**WEST SUSSEX COUNTY COUNCIL
STRATEGIC PLANNING CONSULTATION**

44, Lyminster Road, Littlehampton, West Sussex, BN17 7LB

APPLICATION NO: LU/281/15/HH

Description of Works: Vehicular access & crossover with provision of porous parking space within boundary. This application may be determined by Littlehampton Town Council under delegated powers.

Drawing No 15/15/06

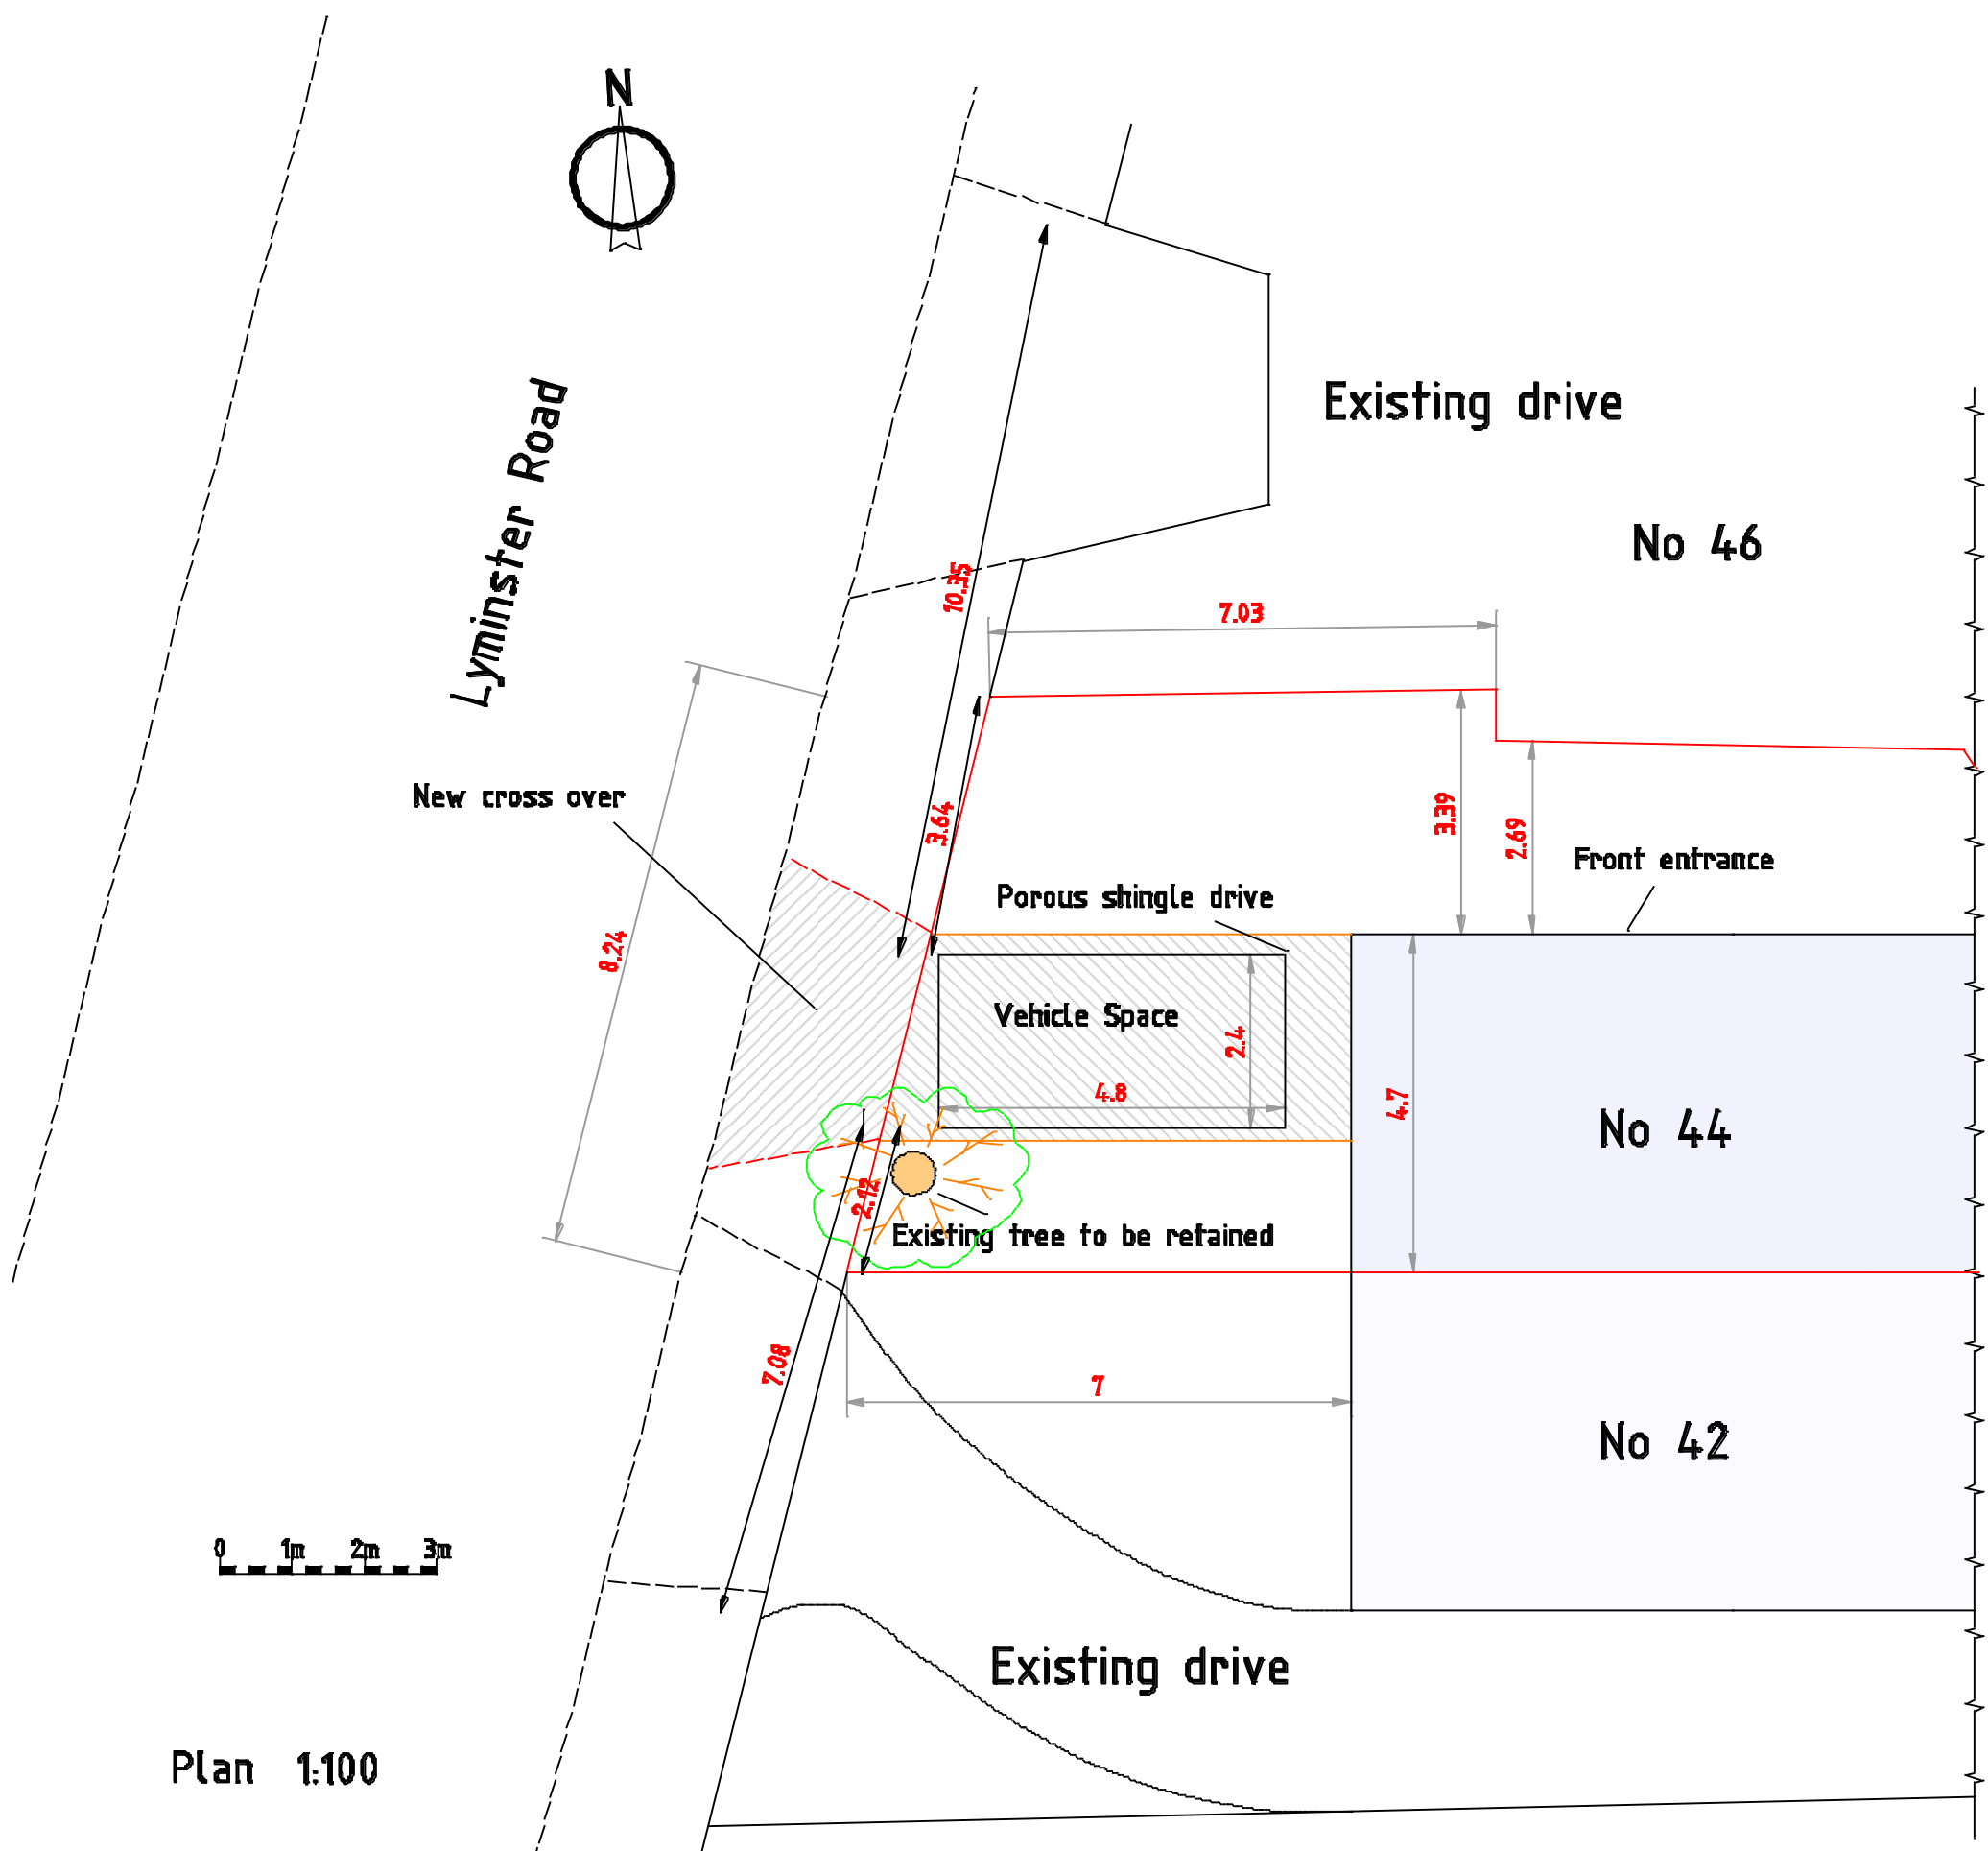
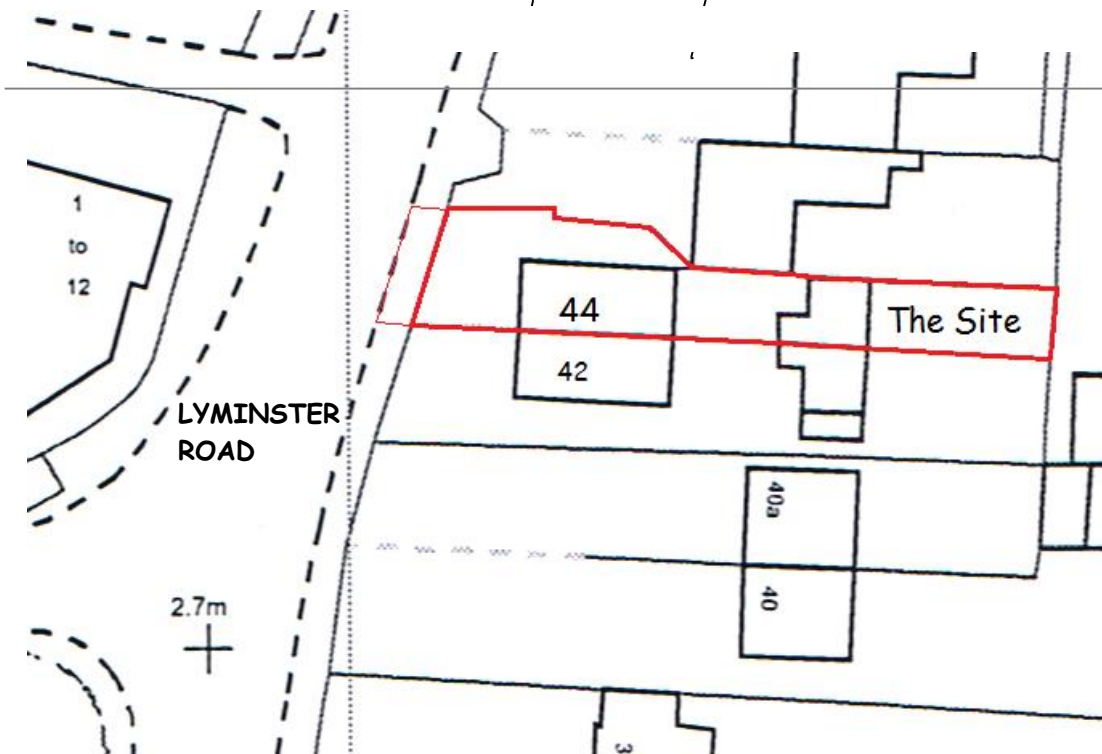
In terms of visibility it would be advised that maximum achievable visibility splays using 2.4 metre 'X' distance be secured, inasmuch as is under control of the applicant. This may have an impact on the remaining boundary treatment fronting Lyminster Road.

An appropriate amount of hard standing can be provided, minimum of 2.4 x 4.8 metres, to provide an off street car parking space. The hard standing is to be constructed from gravel. This may result in material being dispersed onto the public highway affecting the surface of the road. The applicant should provide a gravel trap or area of block paving, or other bound material, at the point of access onto Lyminster Road on land within the applicant's control; not within the publicly maintained highway. Alternatively the whole of the hard standing can be laid in a bound porous surface.

Advice should be sought to in relation to implementing the proposed hard standing and the impact on the adjacent on site tree. It would however be concluded that retaining this tree would not significantly obstruct visibility.

The crossover must be installed under licence to a specification obtained from WSCC Highways.

- Access
- Parking Space
- Maximum Achievable Visibility (Splays 2.4 X Maximum Achievable, inasmuch as is under control of the applicant)
